DECISION DELEGATED TO HEAD OF PLANNING

Application No:	H17-0811-22	Applicant:	Ashley King Developments Ltd
Proposal:	Details of archaeological investigation, flood risk assessment and drainage strategy measures, proposed boundary treatments, publicly accessible open space, protected species report, open space management plan, storage and disposal of refuse and recycling, protection of trees, protection of existing hedge, swift nest bricks/boxes, external materials, Sunnydale Close access, gas and electricity external boxes, construction management, estate road phasing and completion plan, surface water disposal and design & location of road/footpath lighting. (Conditions 3, 4, 6, 7, 8, 9, 10, 11, 12, 13, 14, 15, 16, 17, 18, 19, 20, 21 and 22 of H17-1187-21)		
Location:	Land Off Sunnydale Close Surfleet Spalding		
Terminal Date:	20th January 2023

CONDITION COMPLIANCE. Details of archaeological investigation, flood risk assessment and drainage strategy measures, proposed boundary treatments, publicly accessible open space,

SCALE: 1:500 @ A1	DATE: 27.04.2022
DRAWN: AR	REV: H
DRAWING No: 118 - BT - 01

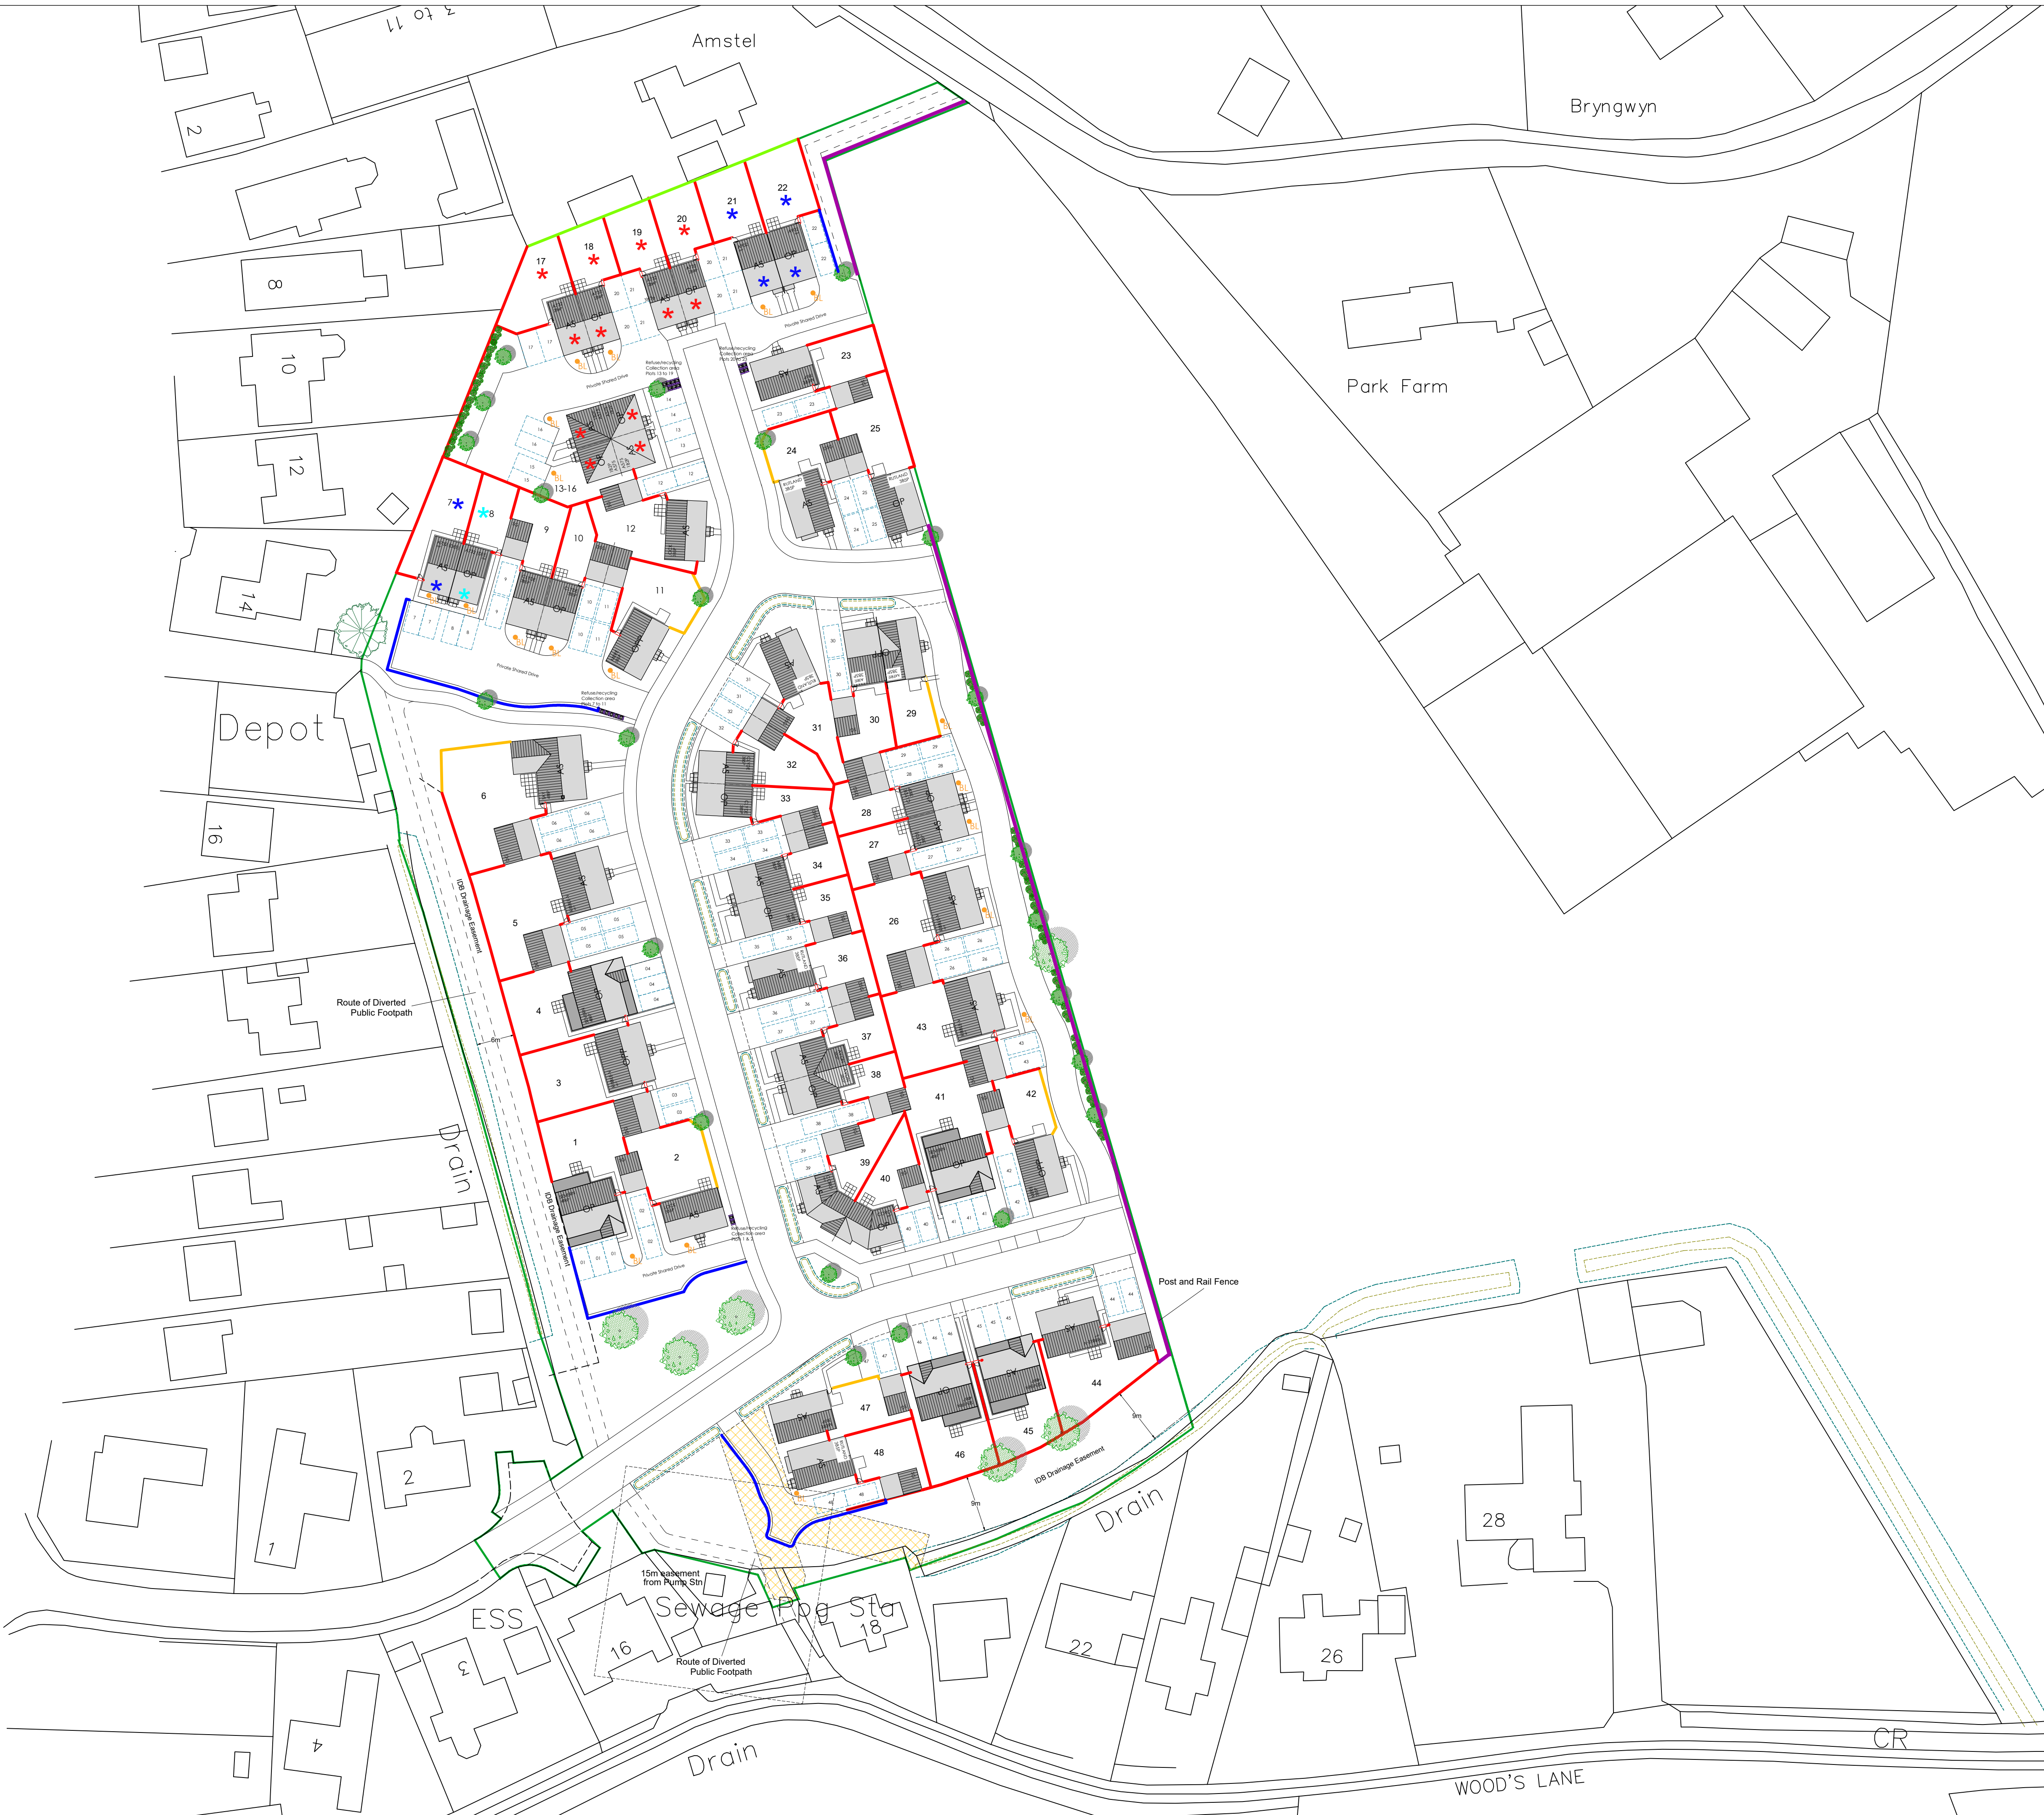
Location of path to rear of Woods Lane properties; not originally approved and should be removed from scheme.

Detailing of publicly accessible open space has been provided and is considered to be acceptable. An objection has been received to the formation of a footpath to the rear of properties in Woods Lane. The layout submitted shows the formation of a 9 metre access strip for IDB purposes and the landscaping scheme has been revised to remove the mown footpath.

DRAWING No:
118 - SS - 01

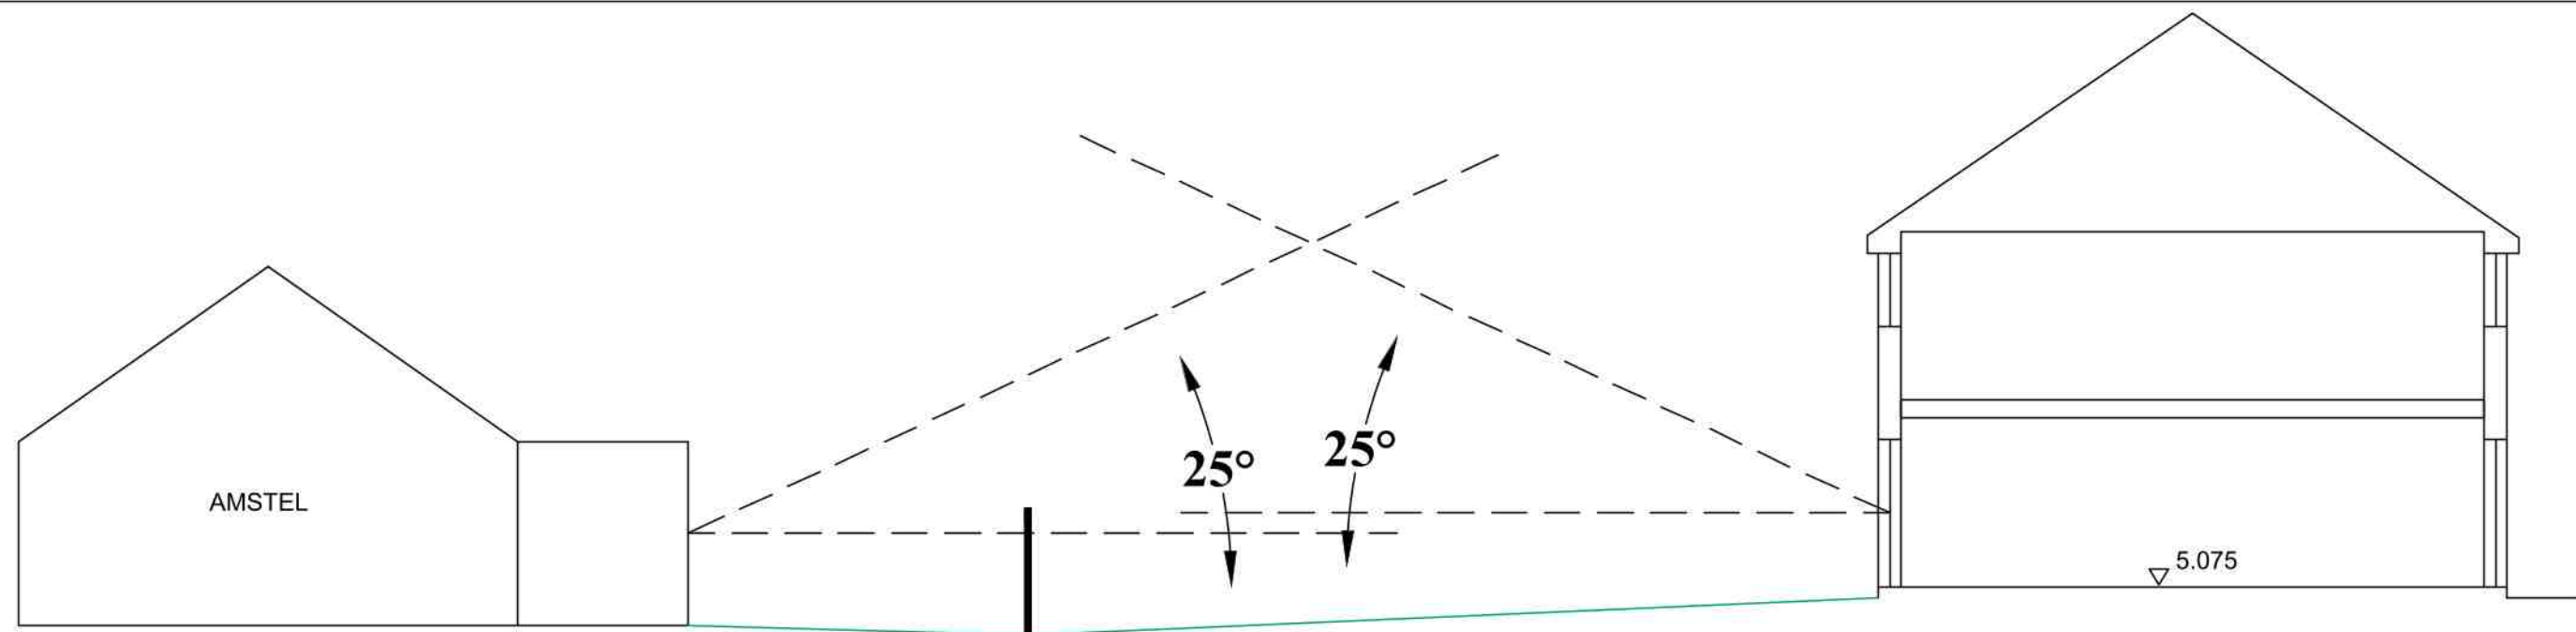
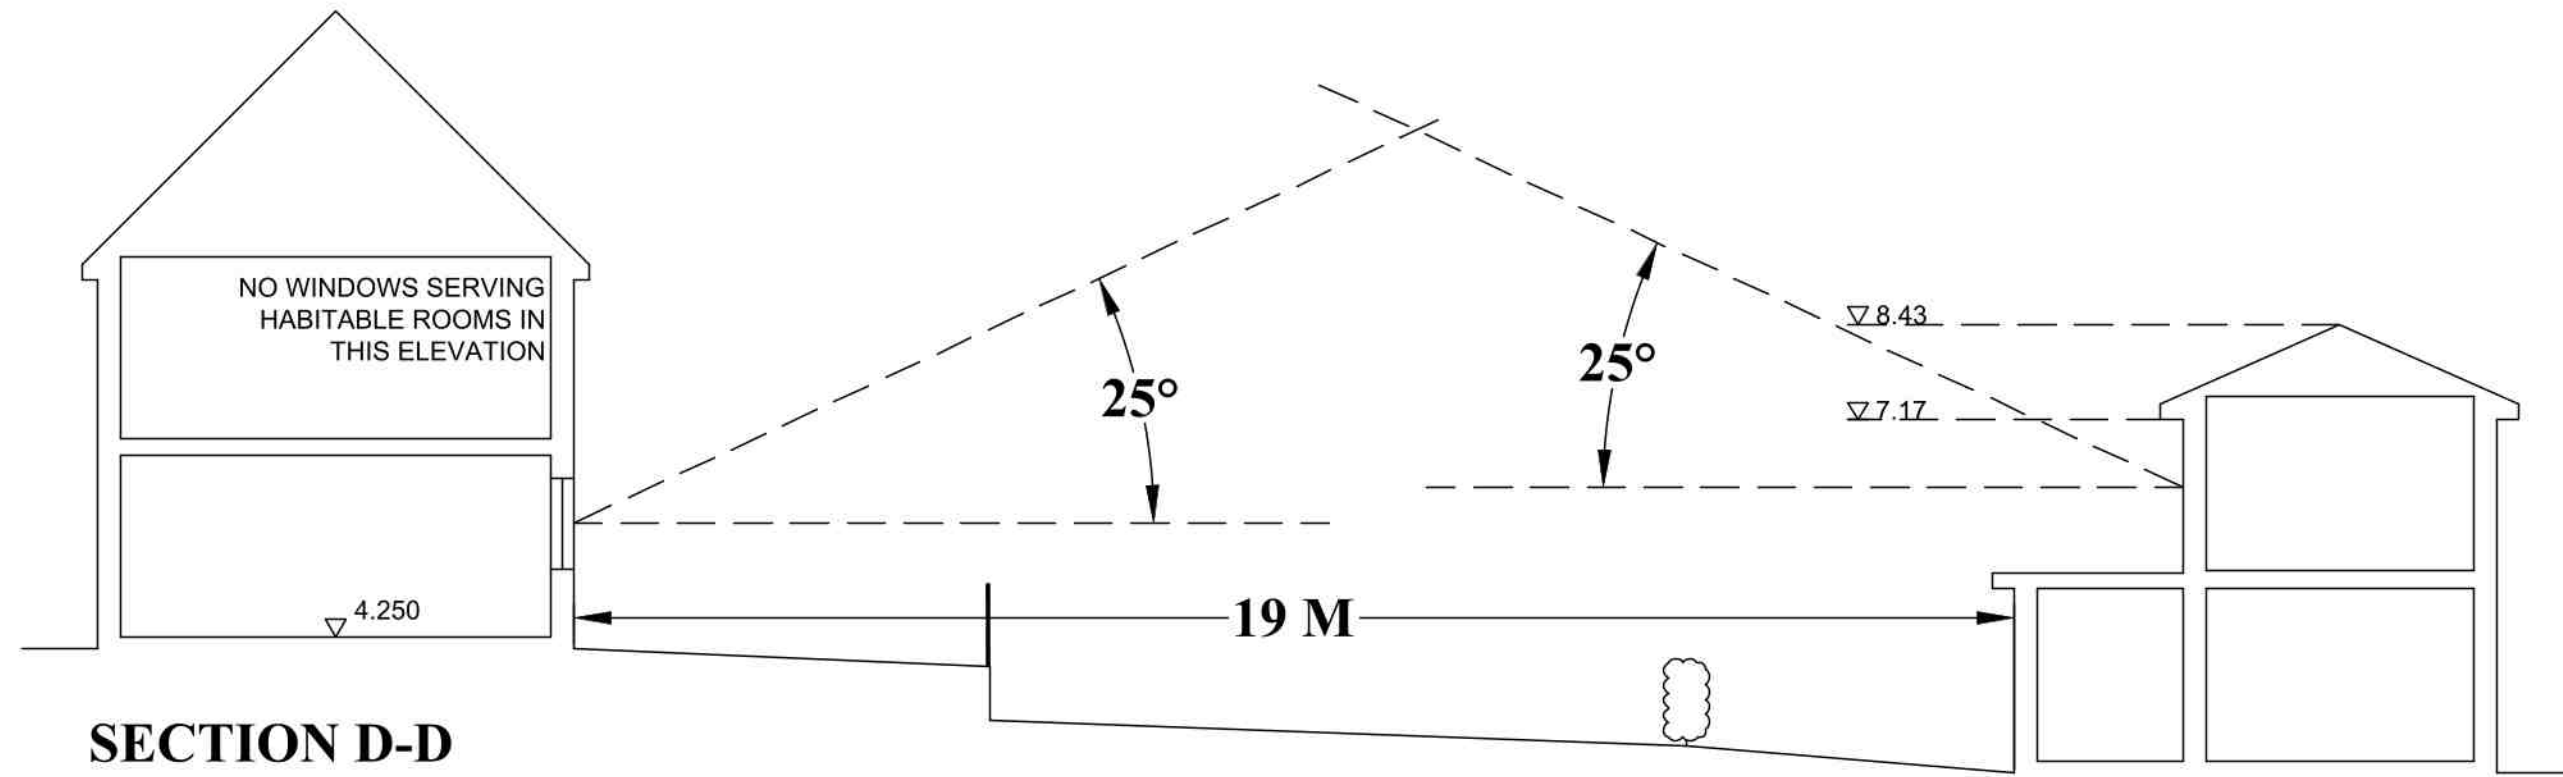
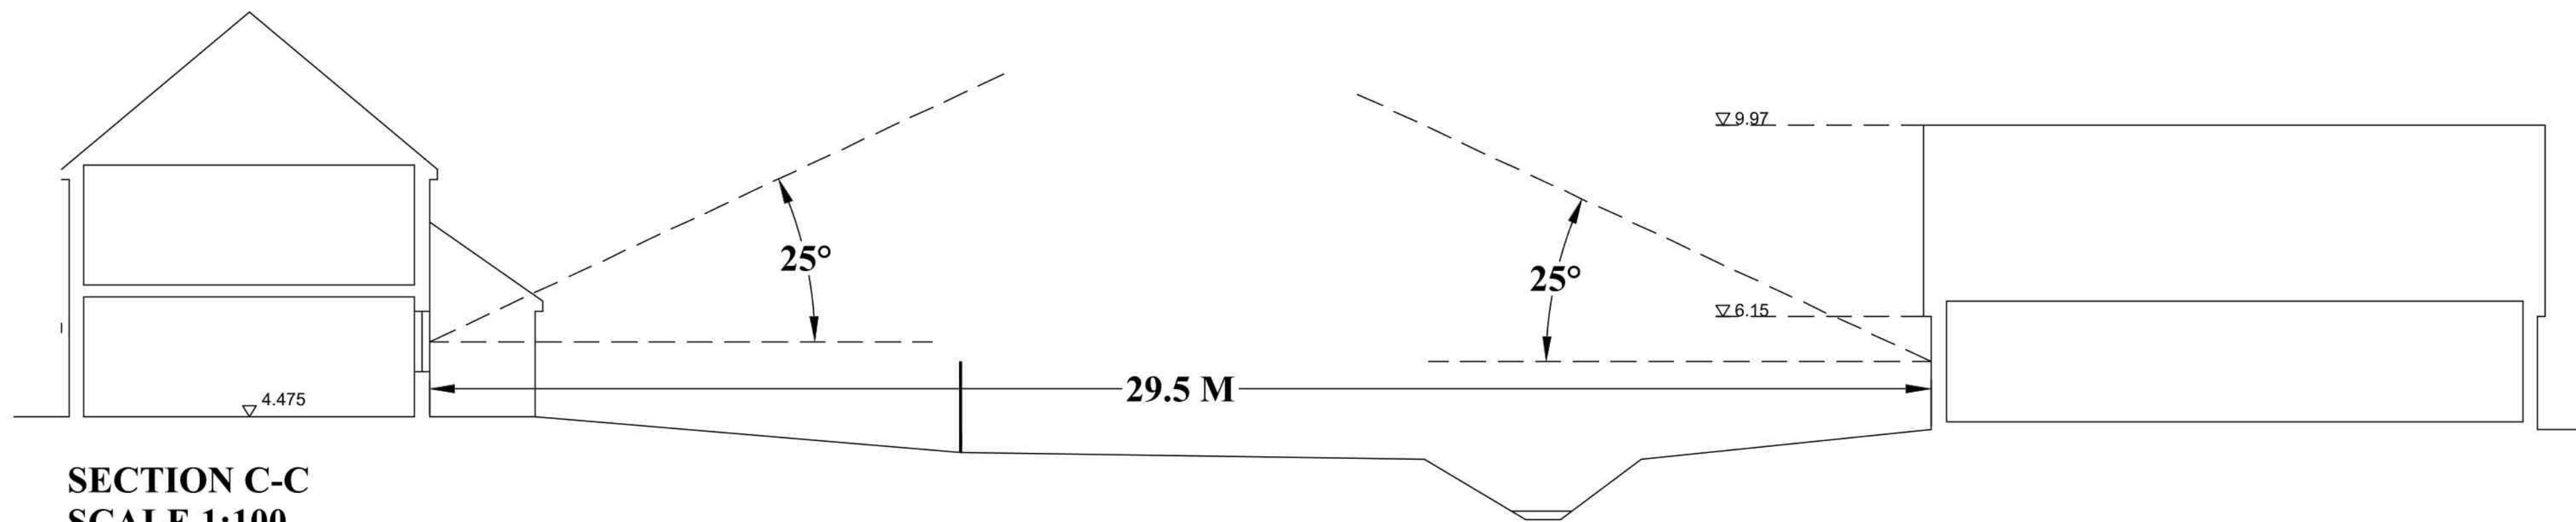
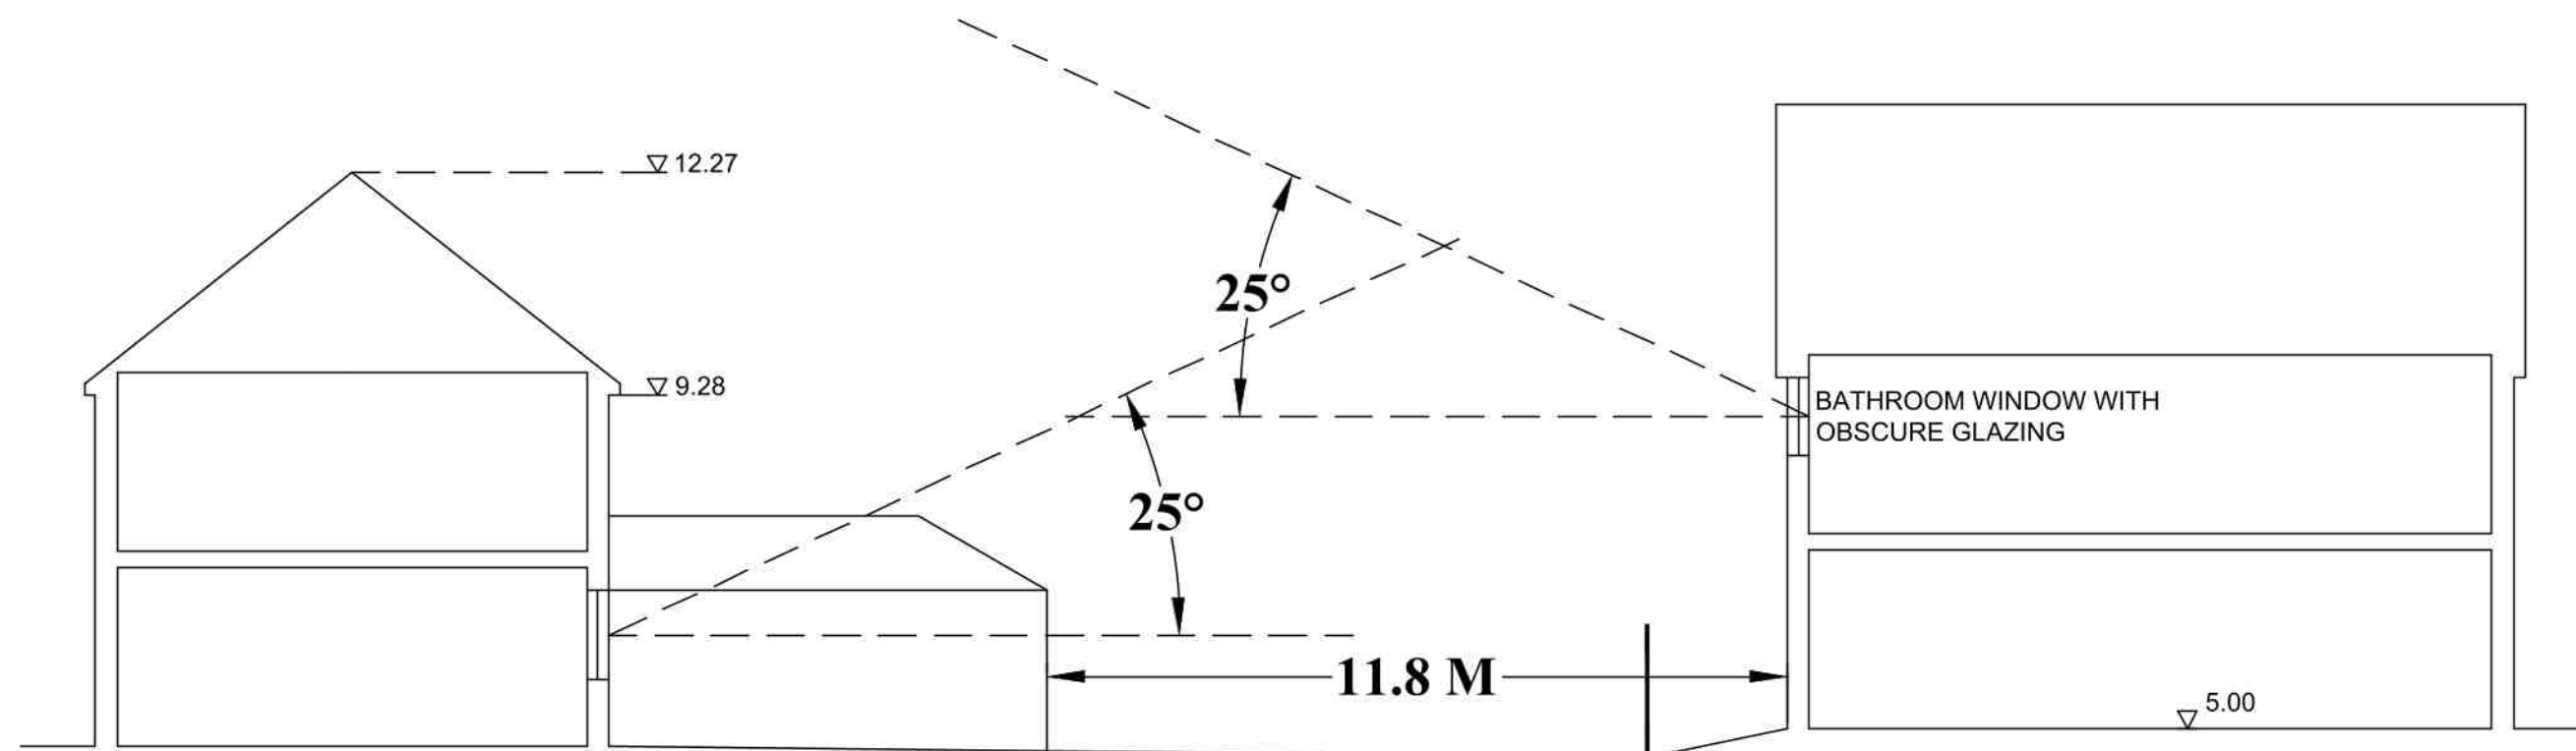
It can be seen from the sections through the edges of the development that this is another site that is to be raised above adjacent existing development - presumably to mitigate against fluvial/coastal flood risk.

Whilst the purpose of producing these drawings is presumably to illustrate any potential for the new properties to overlook existing neighbouring properties, they also highlight the potential for surface

water run-off to be cast from the development onto what will become lower-lying neighbouring properties.

It is therefore requested that physical measures are put in place, wherever the development abuts existing residential properties, to intercept and dispose of any surface water run-off so that the development does not increase surface water flood risk to those neighbouring properties.

Thank you for your notification of receipt of amended details for this Application that show the arrangements to be put in place for the interception of any boundary surface water run-off from the proposed development to prevent it being cast onto existing residential properties adjacent to the site. I can confirm approval of these proposals on behalf of the lead local flood authority.
